ENGINEERING DESIGN PROFESSIONALS
Consulting Engineers

RE: Exterior Wall Evaluation for Remodel at
223 Cumberland Ave, Portland, Maine
Project # 02915

Wall Evaluation

TYPICAL WALL SECTION
SCALE: 1/2"=1'-0"

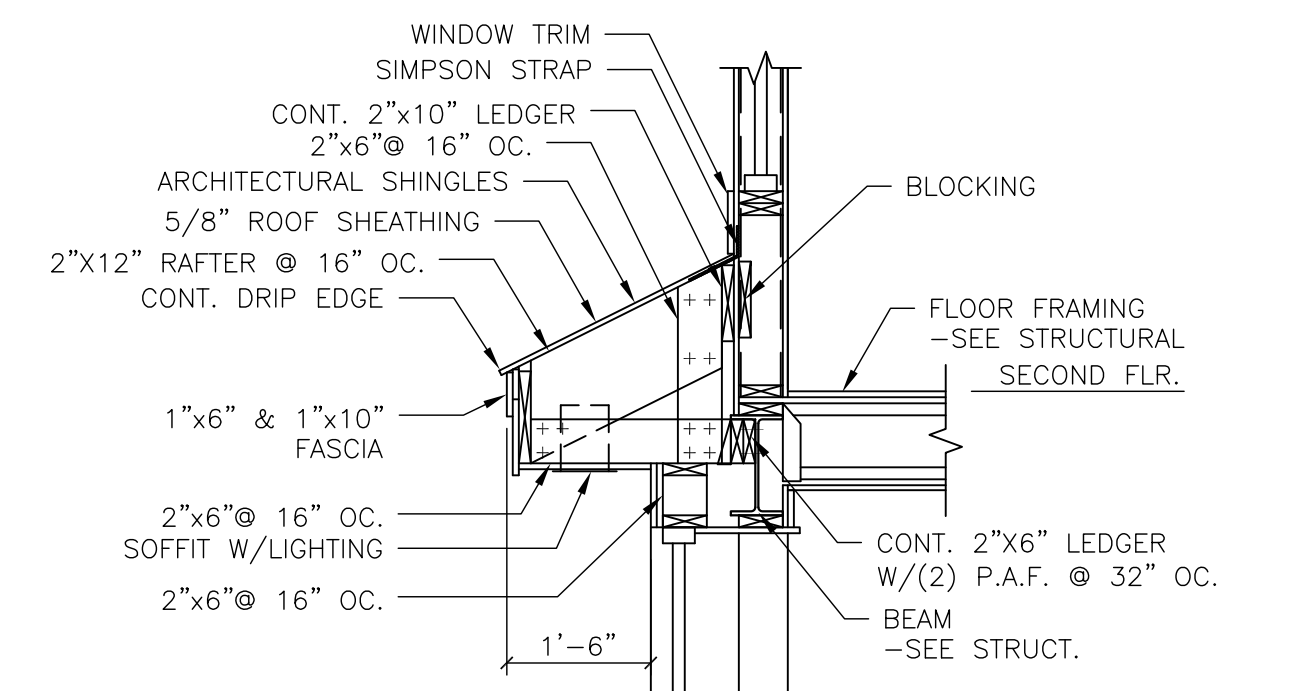
During the progress of the reinforcement project, I made observations of the existing exterior wall framing that concerned me but did not present an immediate danger to the construction crew at the time. This wall framing that was originally supporting the floor systems and roof is under sized and poorly constructed to resist current gravity and wind loading requirements. Fortunately the reinforcement project has removed any gravity loading forces from the walls and provided another system for transferring wind loads to the foundations.

However, the exterior wall system is still in poor condition and even though it only exists as a skin to the building, there is still a concern that over time the materials will degrade and fail under applied wind forces. It was noted that fasteners were rusted, connections were under sized and improperly framed, studs were cut and spliced improperly and openings in the walls were poorly constructed.

In addition, the balloon framing conditions of the original exterior wall will present significant hazard to occupants and Public Safety personnel should a fire event occur. The installation of adequate draft-stopping required to mitigate this condition would be invasive, and essentially require the removal of a substantial portion of the exterior finishes and sheathing in the process.

I recommend the removal of the original exterior wall system from foundations to the roof framing. As mentioned the original wall system is no longer supporting the floor or roof systems therefore if dismantled from the top down, there should be minimum need for shoring. In addition, the fastening of the plywood wall sheathing that was added during the reinforcement project can be easily completed at the areas along the floor system.
